RE: MP 09_0146 MOD 1 – EAST LAKES SHOPPING CENTRE

Thank you for your letter received 8 August 2017 regarding the proposed modification to the Eastlakes Shopping Centre, Eastlakes (DPE Ref: MP 09_0146 MOD 1).

**CGE-NS S75W 130003 04**

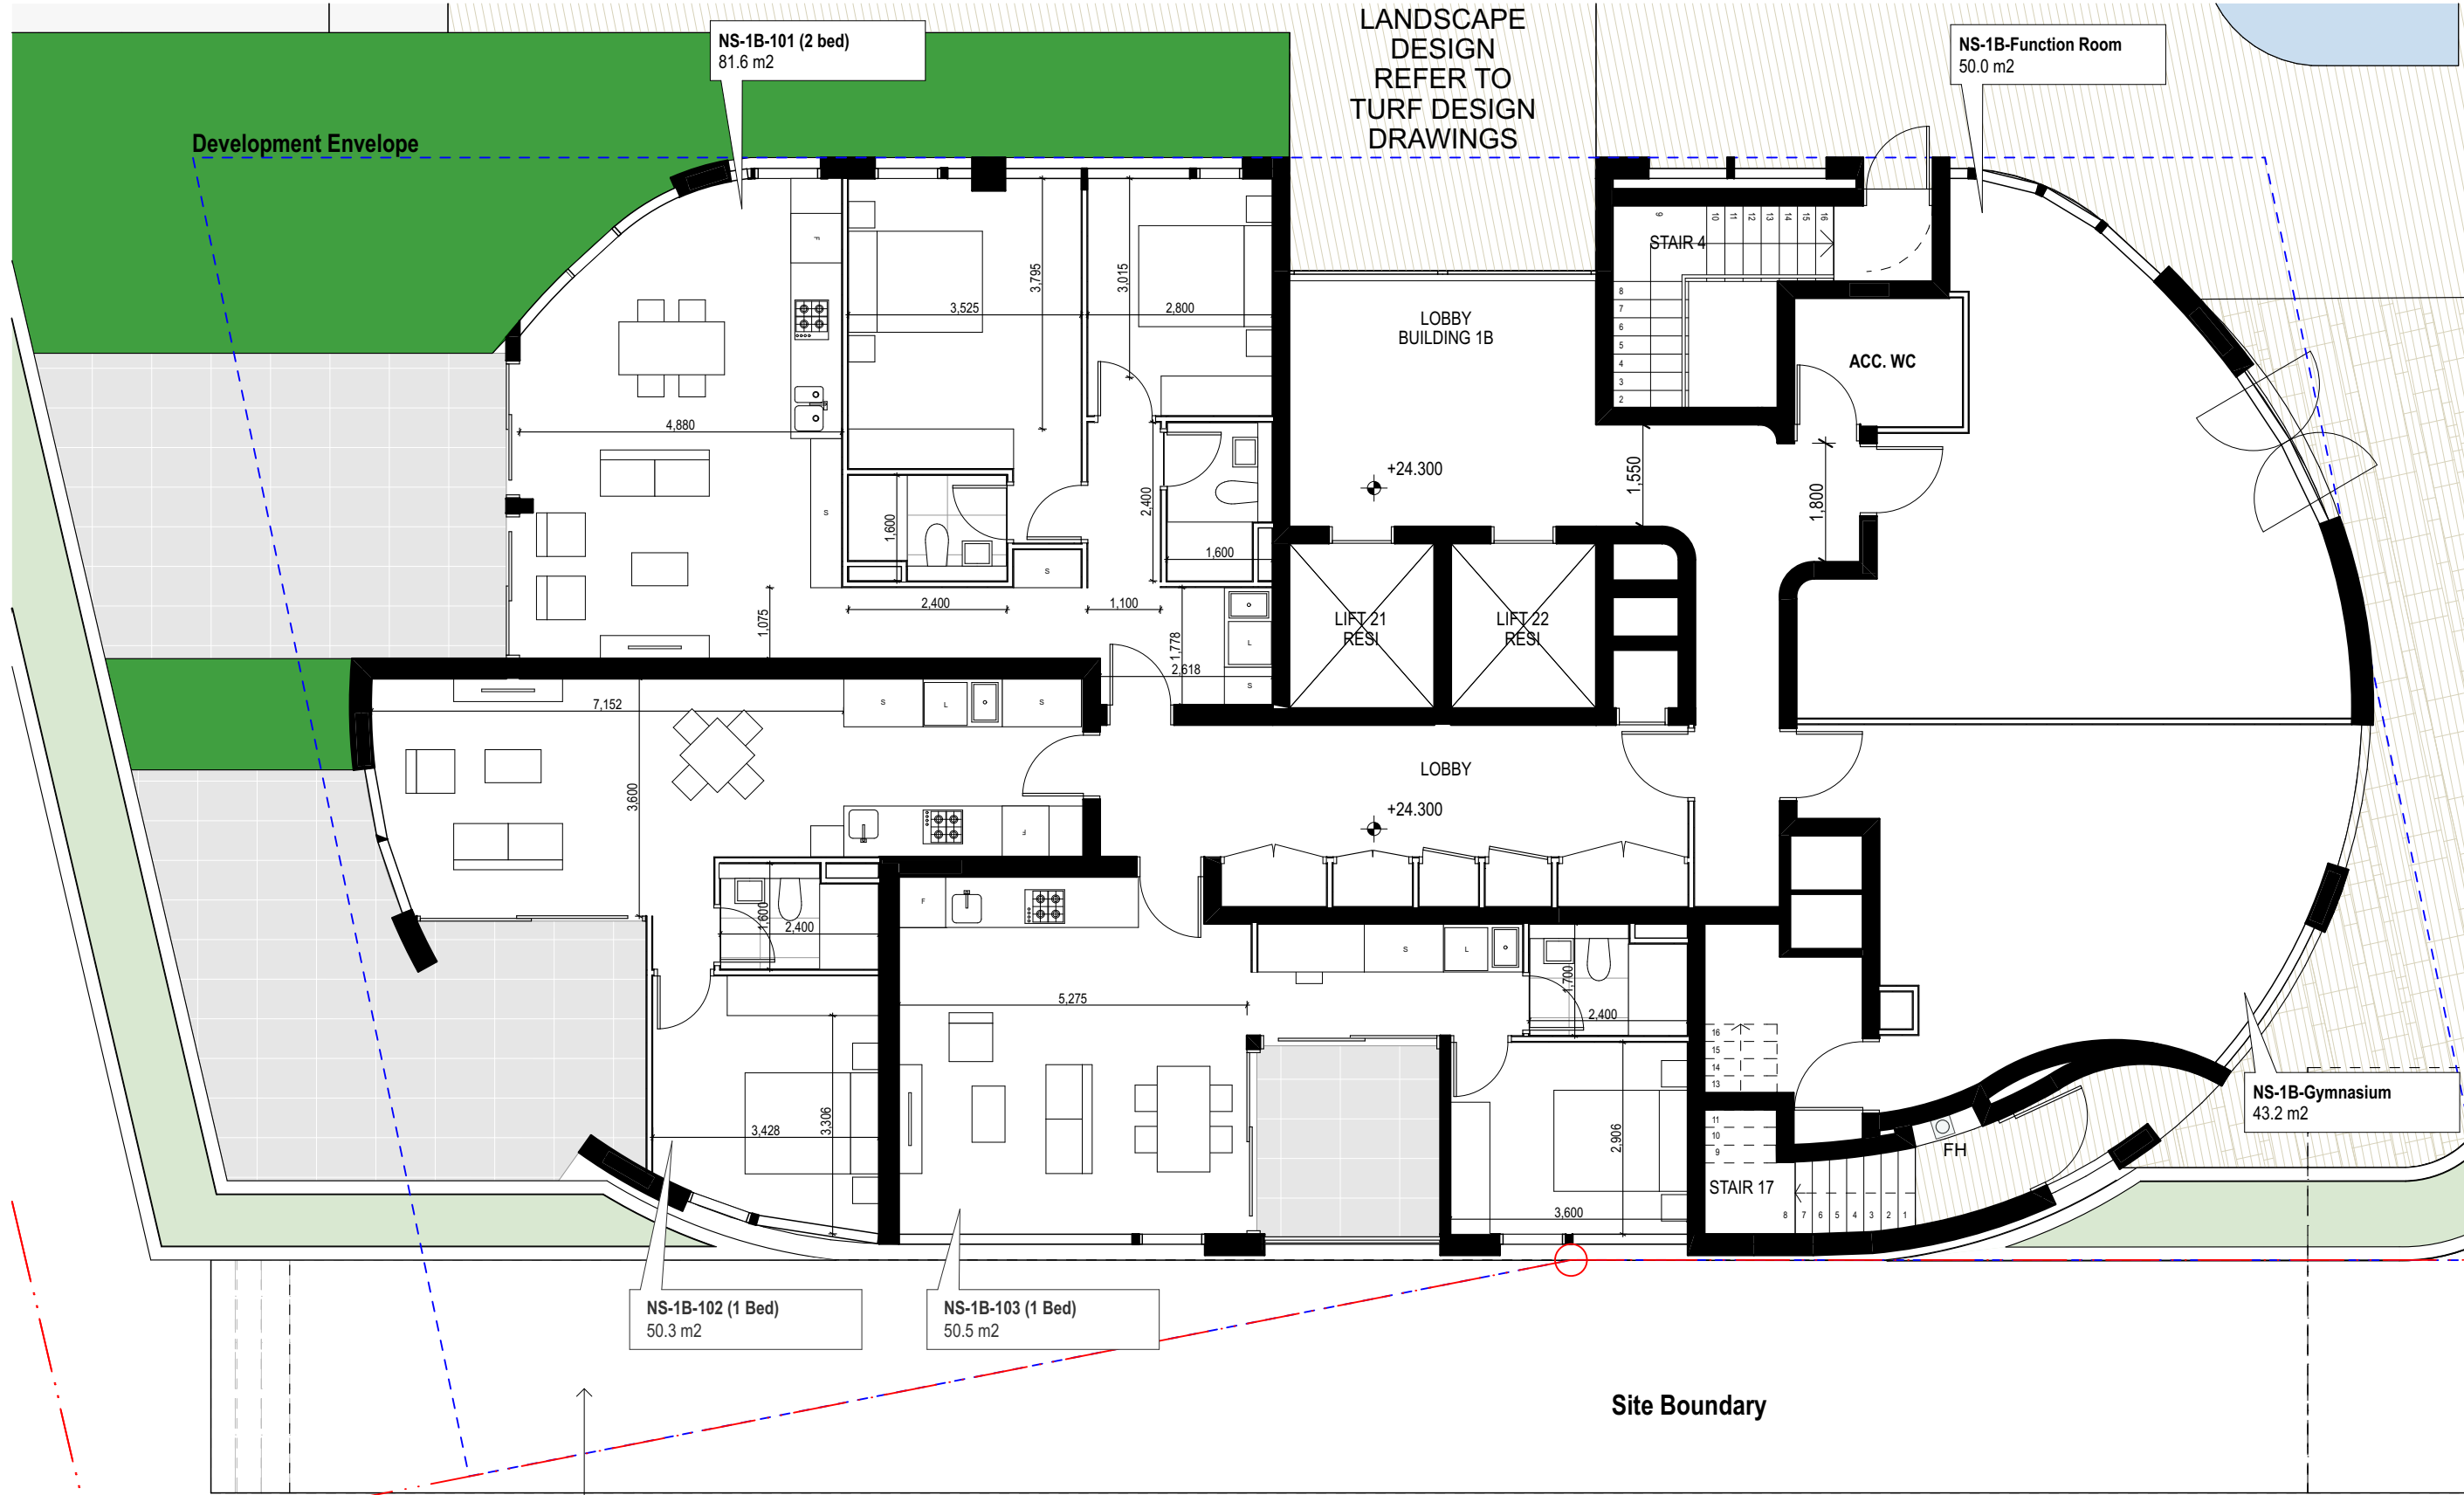
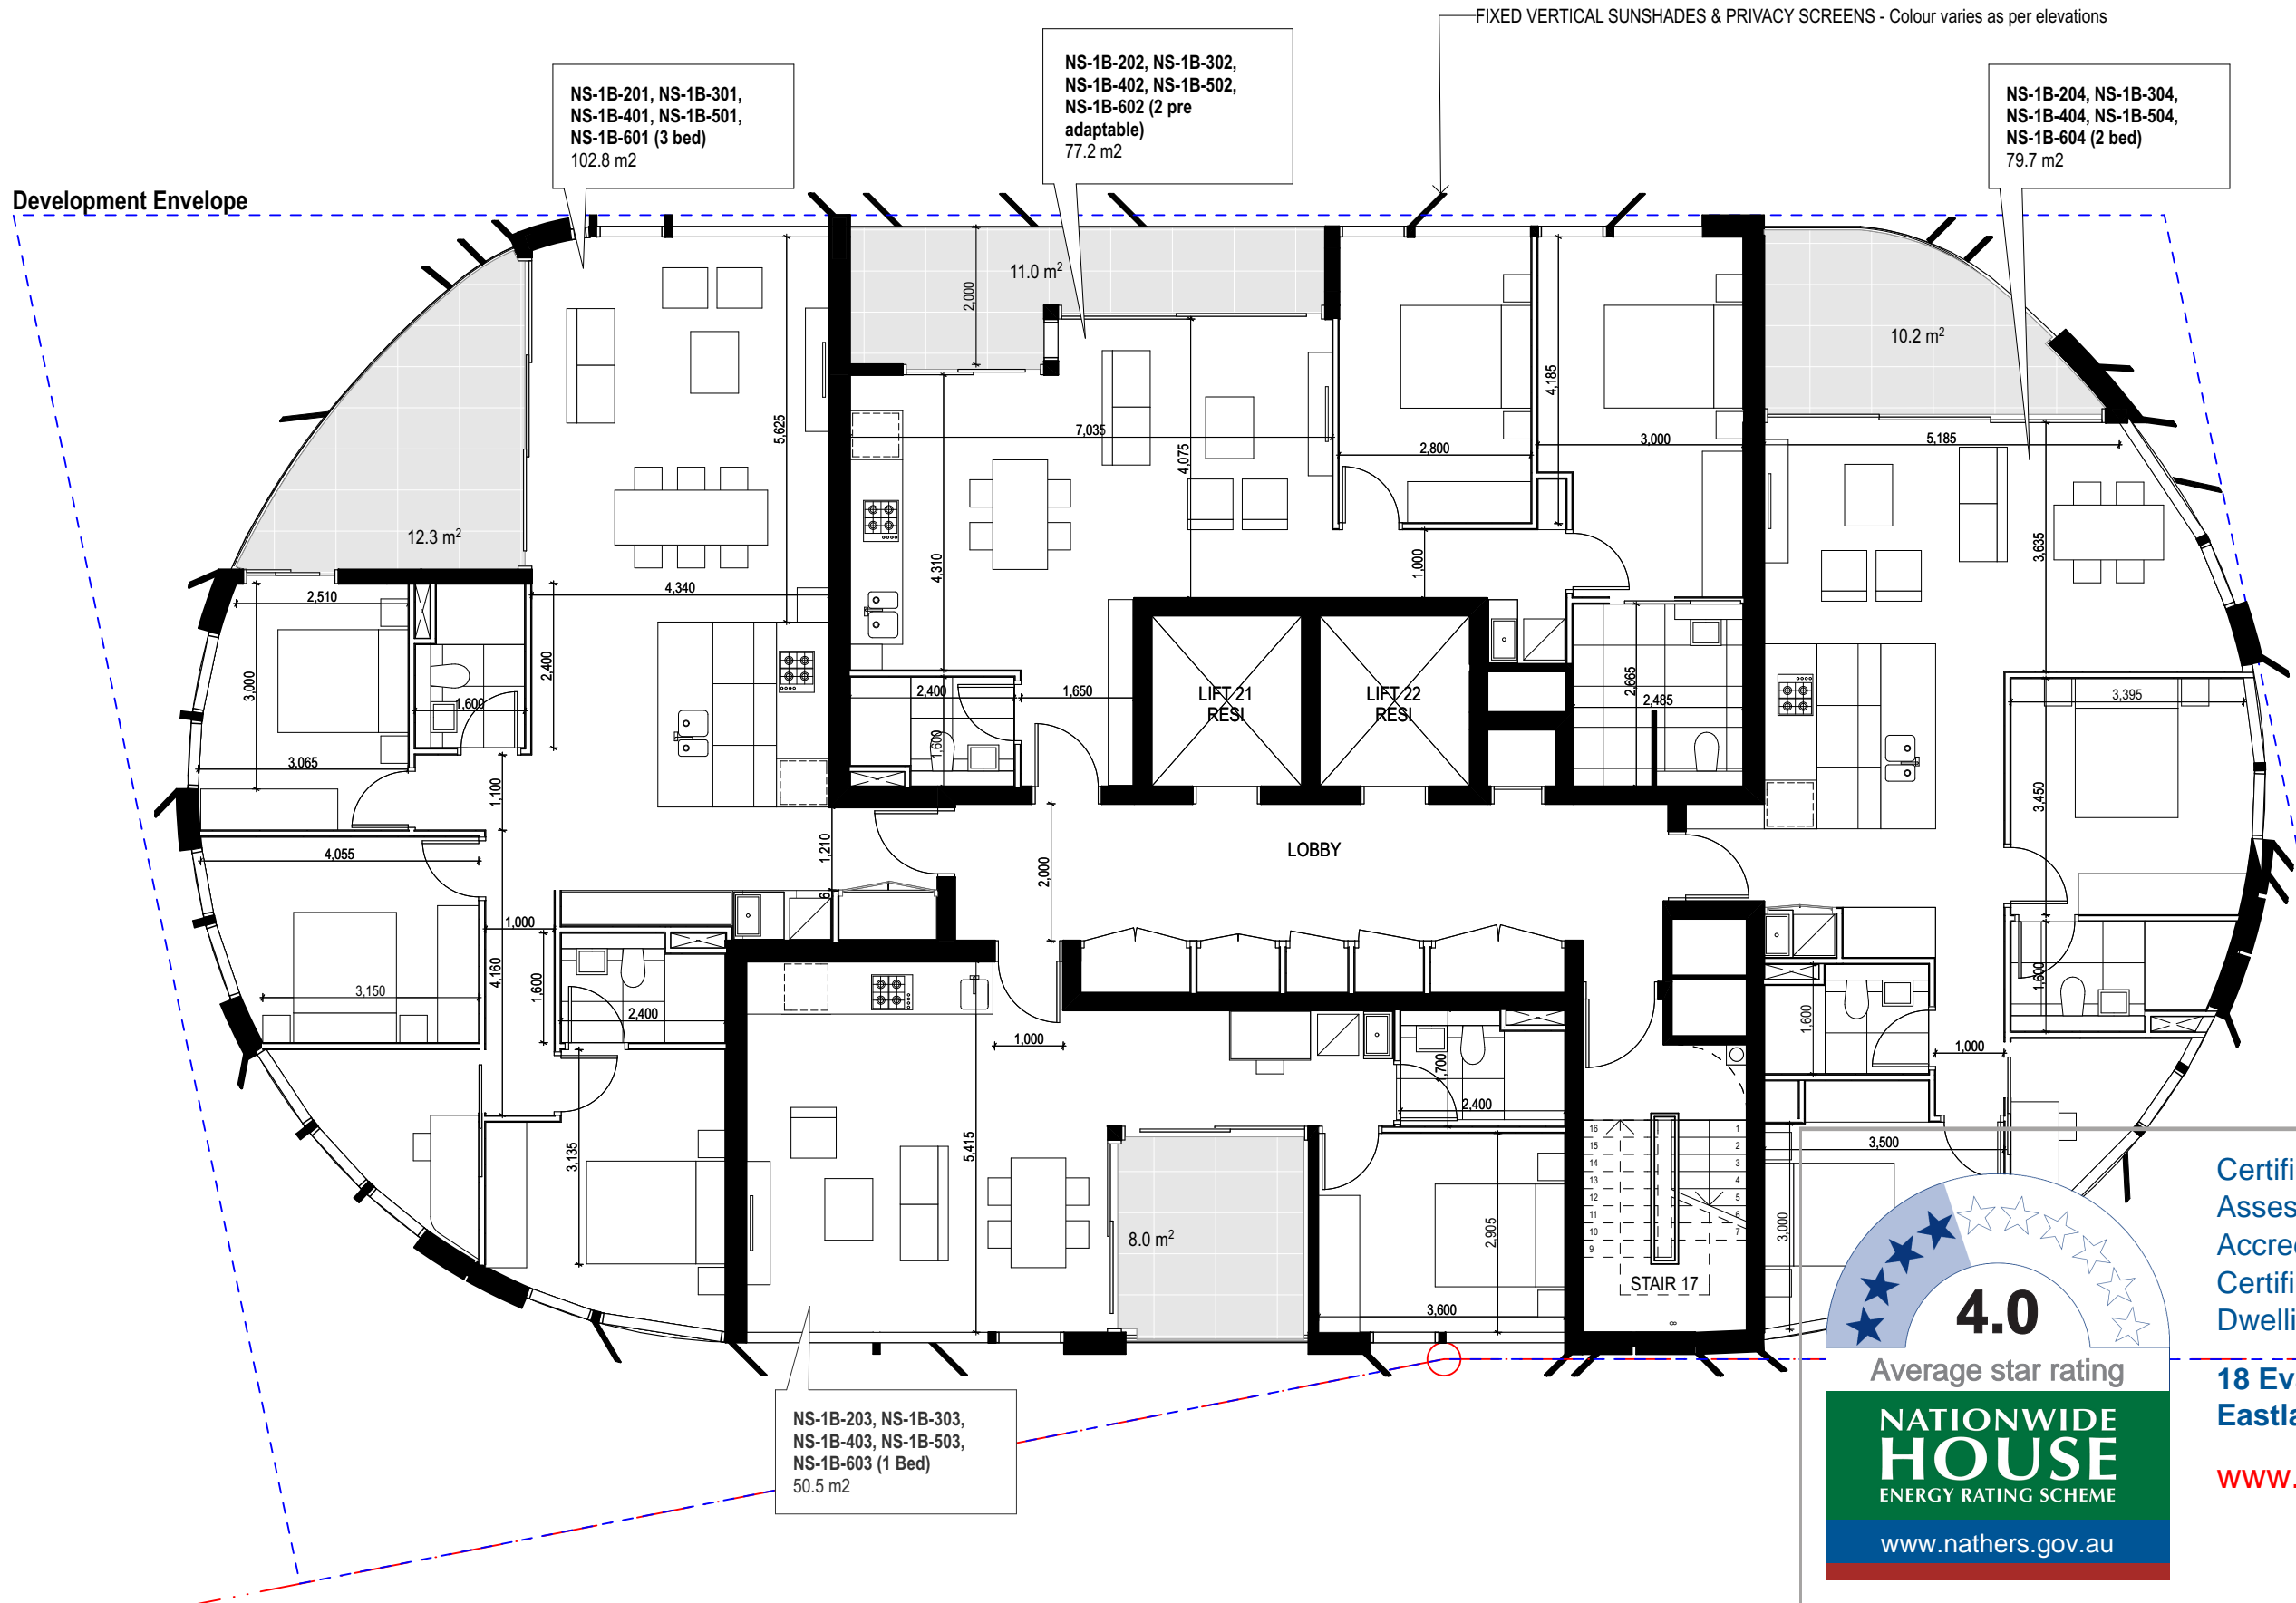
All 3-bedroom apartments in Building B1 are to demonstrate compliance with *Part 4C.4.2 - Family Friendly Apartment Buildings* of the Botany Bay Development Control Plan 2013 (BBDCP 2013).
